**WEST SUSSEX COUNTY COUNCIL
PLANNING SERVICES CONSULTATION**

DATE: 16th November 2017

SUBJECT: LU/278/17/RES - Approval of Reserved Matters following Outline Permission LU/47/11 for Construction of the southern section of the Lyminster Bypass, including northern and southern roundabouts, surface water drainage and landscaping. Departure from the Development Plan & affects a Public Right of Way.

LOCATION: North Littlehampton Strategic Development Site, Land West of Toddington Park, Toddington Lane, Littlehampton, BN17 7PP.

Landscape Proposals: SLB3
Northern roundabout

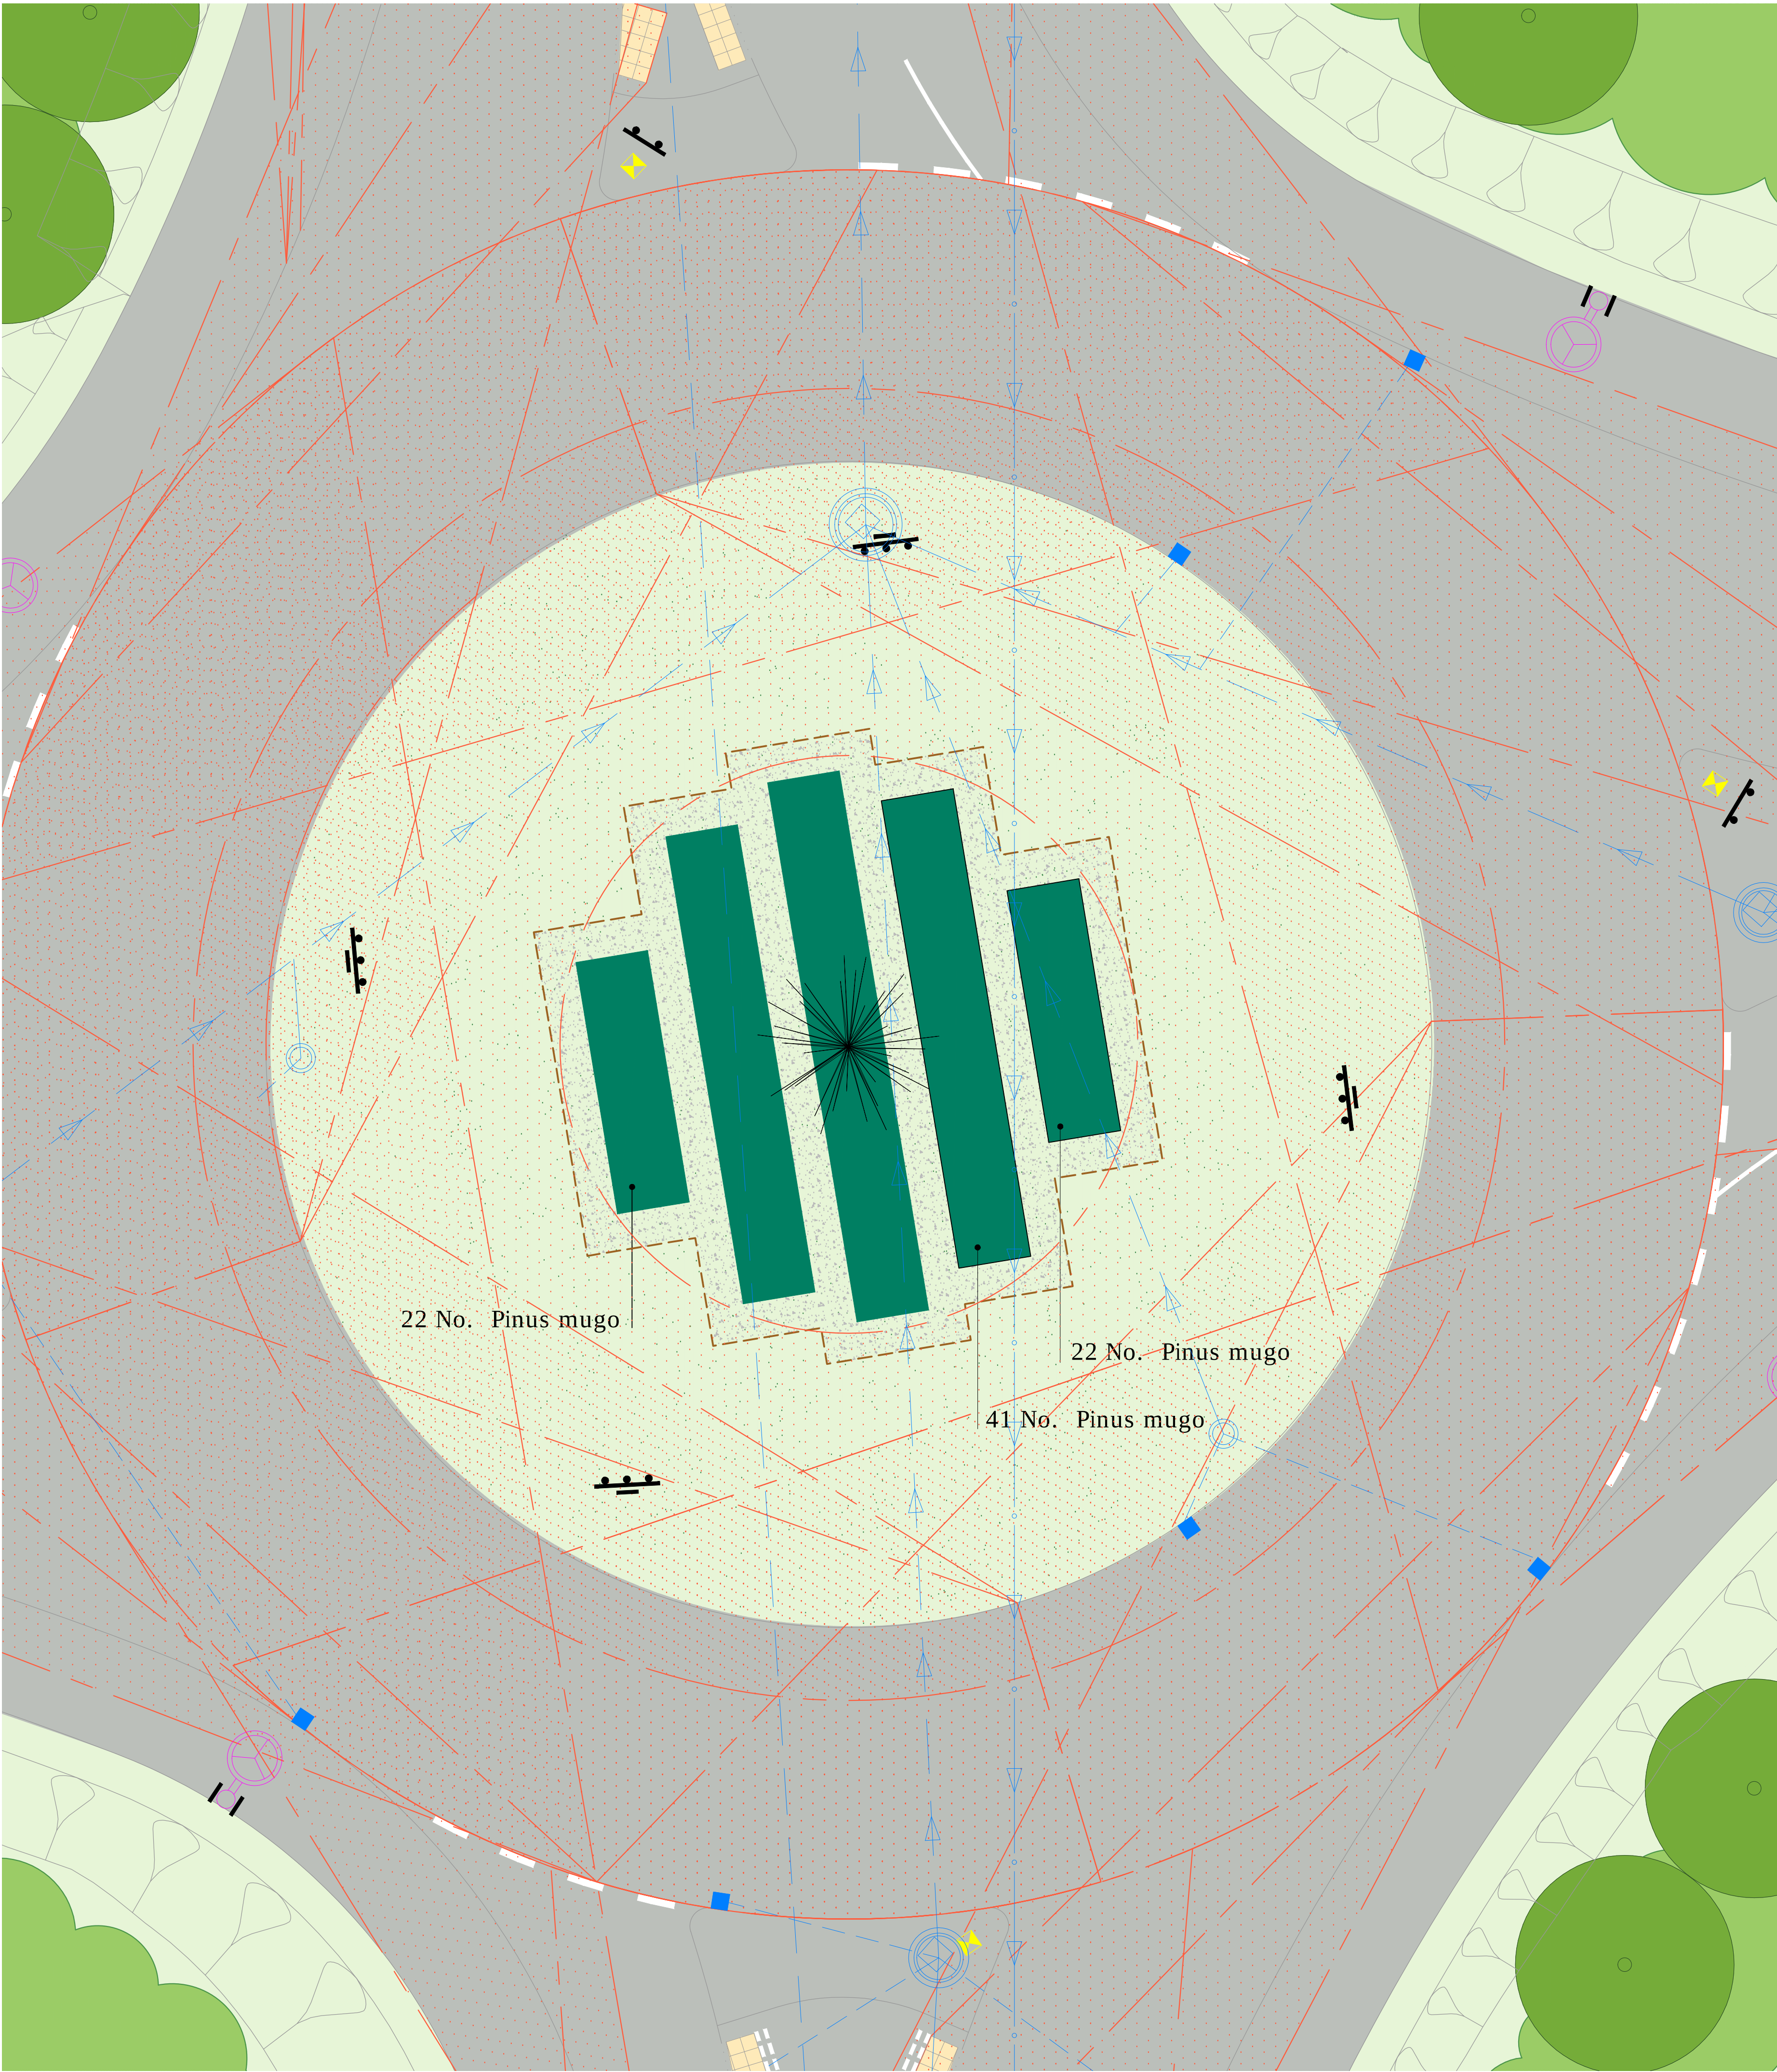
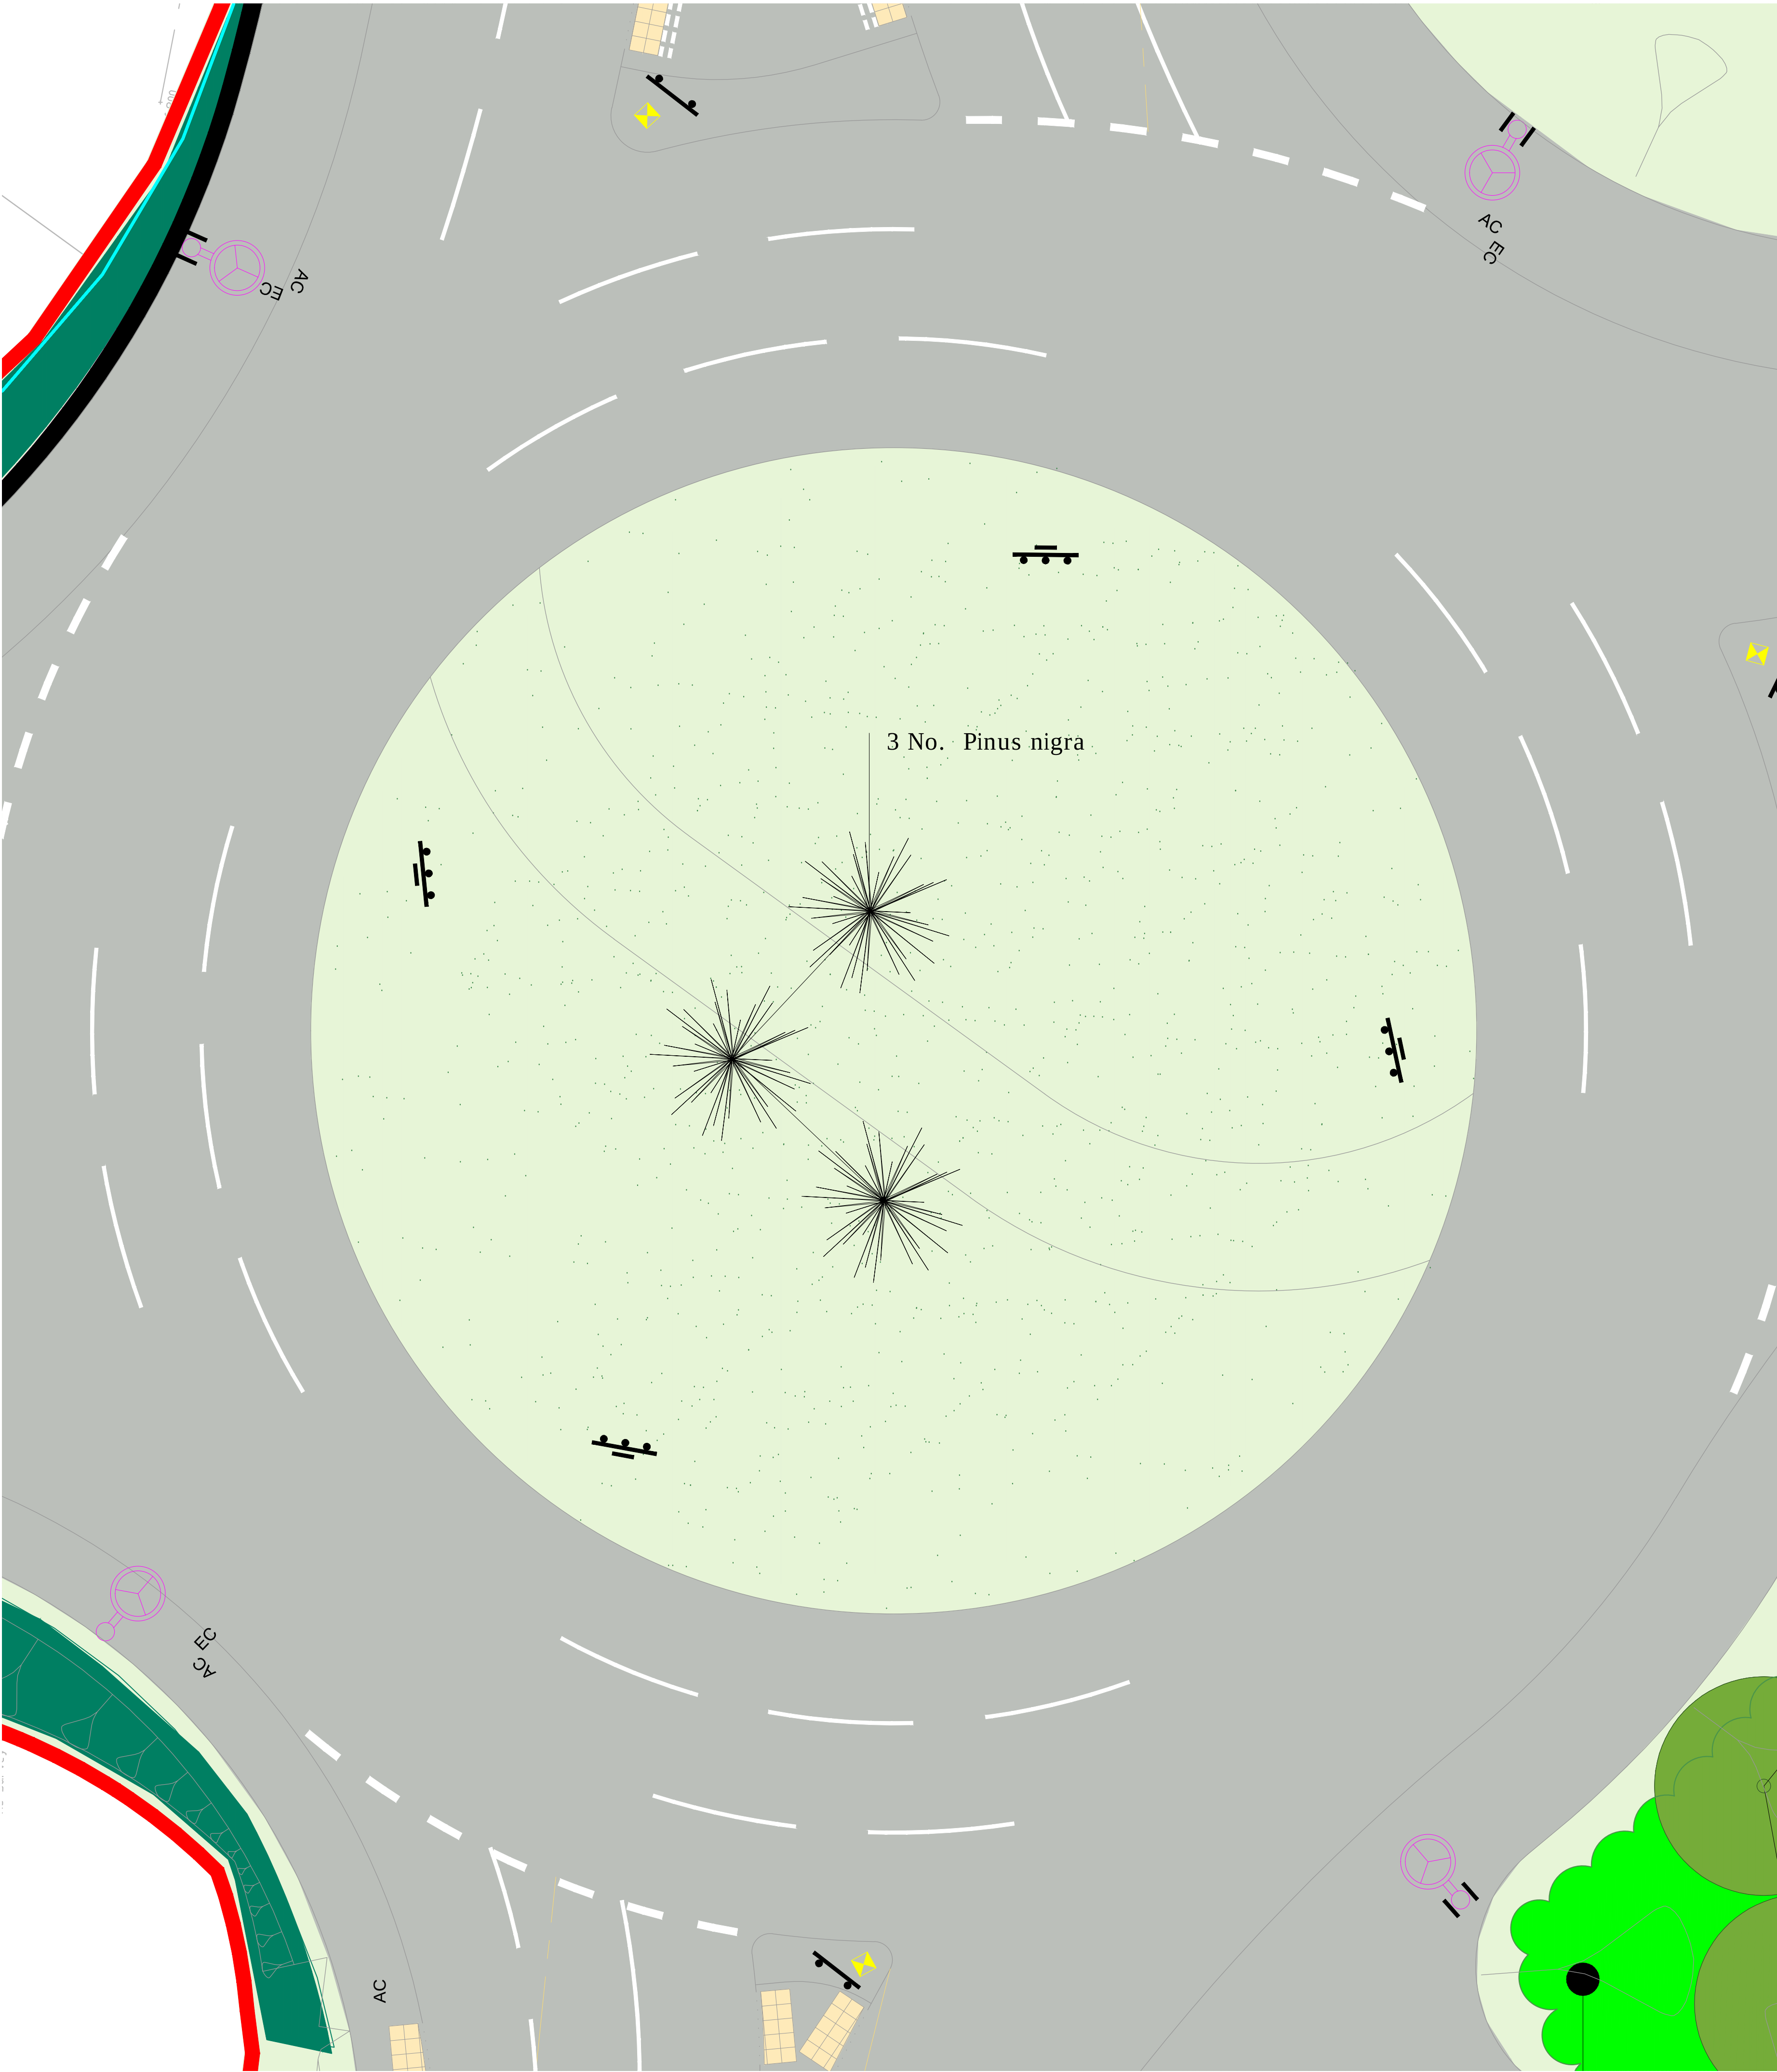
These drawings have no indication what revision they are. This must be included to ensure that they can be specifically referenced in any Decision Notice.

There should be no planting on the cellular storage areas, other than grass.

Thorny planting (blackthorn [*Prunus spinosa*], or otherwise) should not be planted adjacent to or close to cycle paths.

Adequate inter-visibility to be provided at cycle path intersections.

The wooden sleepers on the roundabout islands should be removed as they present a hazard should traffic collide with them. Such features would also hinder maintenance to the underlying cellular drainage system.

Owl boxes – Too close to road. To be removed and re-located.
